Reference: P1049t03v01

30 January 2020

Response to Agency Submissions

New Public School, Estella Road, Wagga Wagga (SSD 9494)

2 PROPOSED PLAN
00_201 1:300

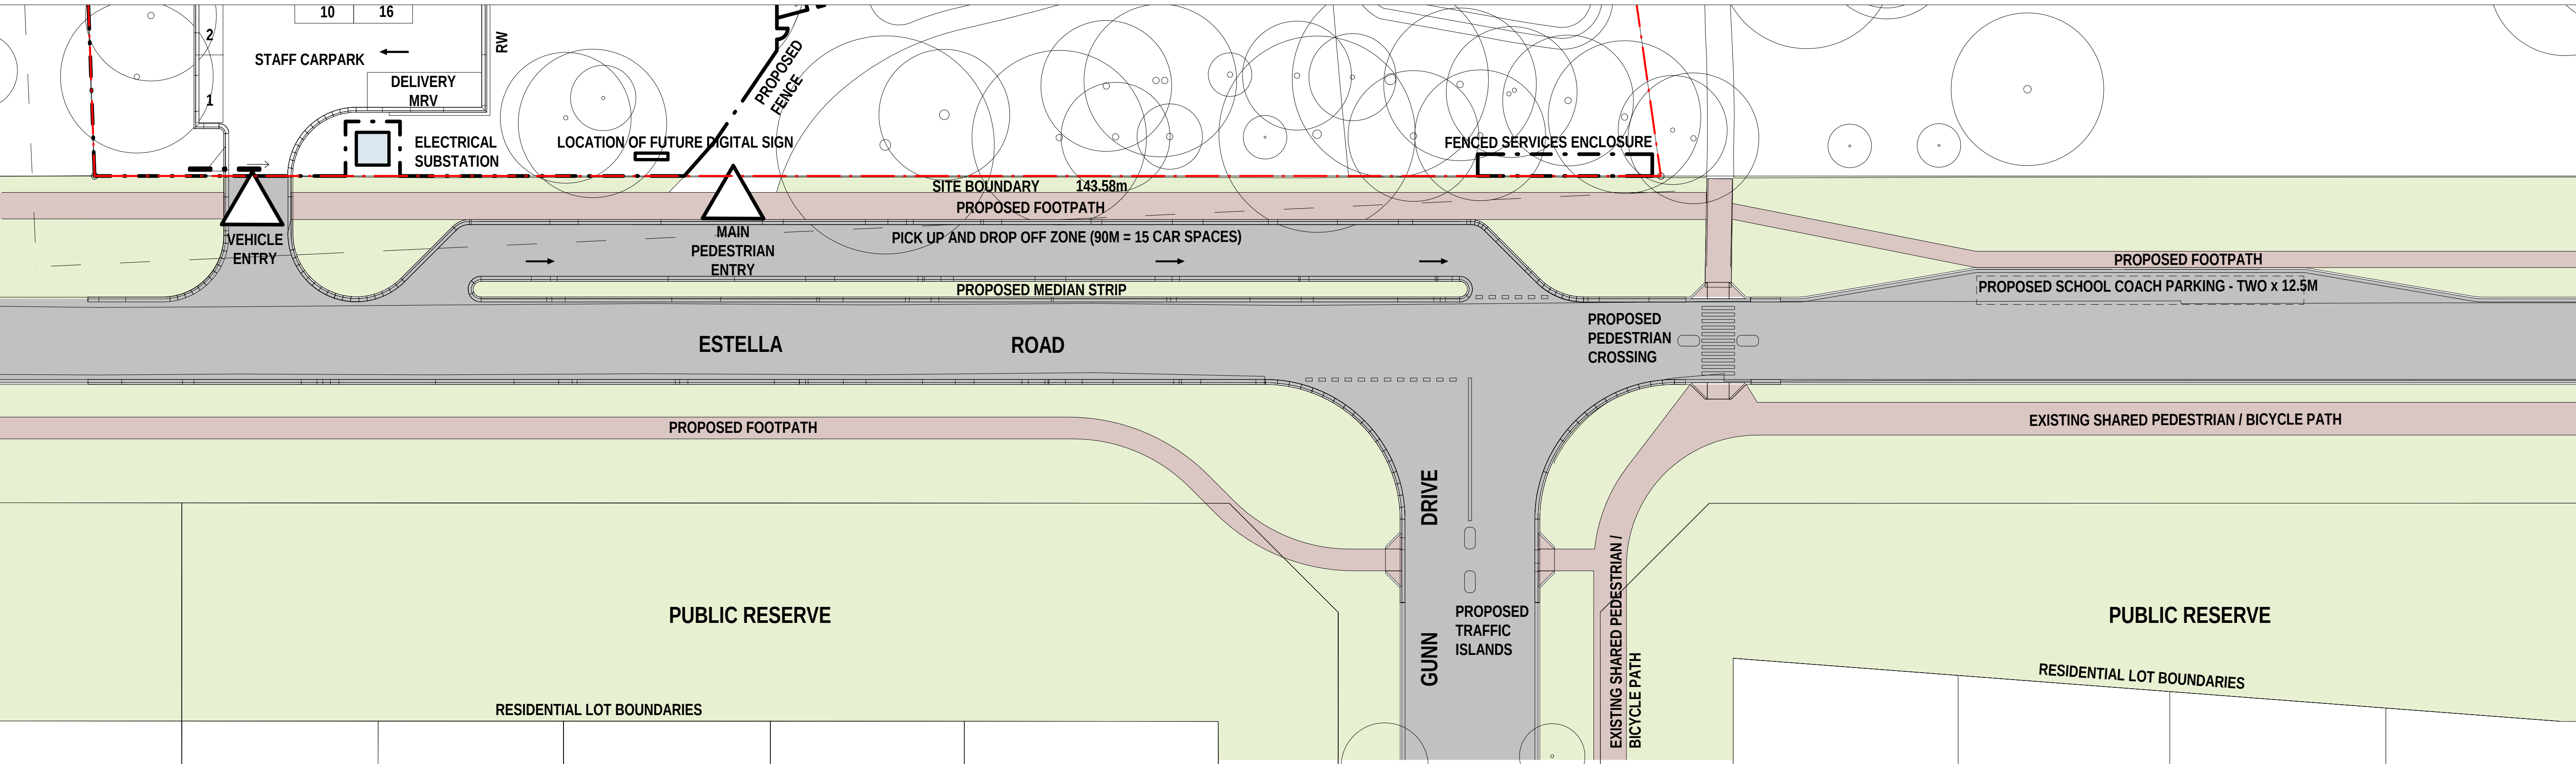
Provide information to demonstrate that the proposed drop-off and pick-up facility would adequately cater for demand, particularly in the afternoon peak which experiences longer dwell times as recognised in the TAR, to avoid queues onto, and informal drop-off and pick-up on, Estella Road. This information is required having regard to the design of Estella Road as a rural type road and potential impacts of informal drop-off and pick-up on road safety and the proximity of the pick-up and drop-off facility to the intersection of Estella Road and Gunn Drive and proposed pedestrian crossings on Estella Road and Gunn Drive.

Provide information to demonstrate that the design of the proposed drop-off and pick-up facility (including the location and design of the entrance and exit), bus bays, pedestrian footpaths and crossings would provide safe and efficient access arrangements to the school, including a road safety audit of the proposed arrangements.

The pick-up/drop-off zone is proposed to be one-way east bound with exit from this facility to Estella Road to be located in close proximity to the approach side to the pedestrian crossing facility proposed across Estella Road. The proposed operation of the pick-up/drop-off zone needs to be managed to ensure the theoretical capacity of the facility as posed by the supporting documentation is achieved.

The TIA in its assessment of the capacity of the pick-up/dropoff zone doesn't appear to consider the delay to vehicles exiting the facility caused by the use of the crossing facility or vehicles wishing to turn right from the facility or turn across Estella Road to Gunn Drive.

It is noted that the TIA recommends that a Traffic and Pedestrian Management Plan (TPMP) be developed by the Department of Education and the School, to be reviewed on an annual basis to establish inefficiencies and areas for improvement, particularly in regard to the operation of the pickup/drop-off zone. As a minimum the exit driveway from the pick-up/drop-off zone shall be designed to allow for a separate left and right turn lane.

The revised, proposed layout of the school frontage on Estella Road shown in **Figure 1** has been modelled in SIDRA using inputs provide by Council and based on Wagga Wagga Spatial Plan 2013/2043. The revised layout consolidates the Drop-Off/Pick-Up Zone (DOPUZ) access with the car park access, effectively extending the DOPUZ to 90 metres. This means that even with the kerbside space being 100% utilised by vehicles, there is still 90 metres available in the passing lane for queueing vehicles.

The results of the additional modelling are shown in **Table 1** and demonstrate that the forecast queue in the DOPUZ for the worst case 2030 AM scenario is a maximum 22 metres. Therefore, there is 68 metres spare capacity that can accommodate any short, anomalous periods of concentrated drop-offs during the AM.

Design of the car park has been in accordance with AS2890 and the DOPUZ has been designed to accommodate the swept path of the largest design vehicle (MRV). All of the facilities associated with the school have been designed in accordance with the appropriate standards and guidelines. However, due to the need to wait for the availability of data to conduct warrants for crossings, it is appropriate to conduct a Road Safety Audit once these have been finalised. It is expected that this would form a condition of consent in any forthcoming determination.

The results of the additional SIDRA modelling show that the forecast queue in the DOPUZ for the worst case 2030 AM scenario is a maximum of 22 metres. Therefore, there is 68 metres spare capacity that can accommodate any short anomalous periods of concentrated drop-offs during the AM and/or any additional delays that may be experienced by the effect of the crossing.

The exit driveway from the pick-up/drop-off zone has been designed to allow for a separate left and right turn lane and the additional modelling has also incorporated this configuration.
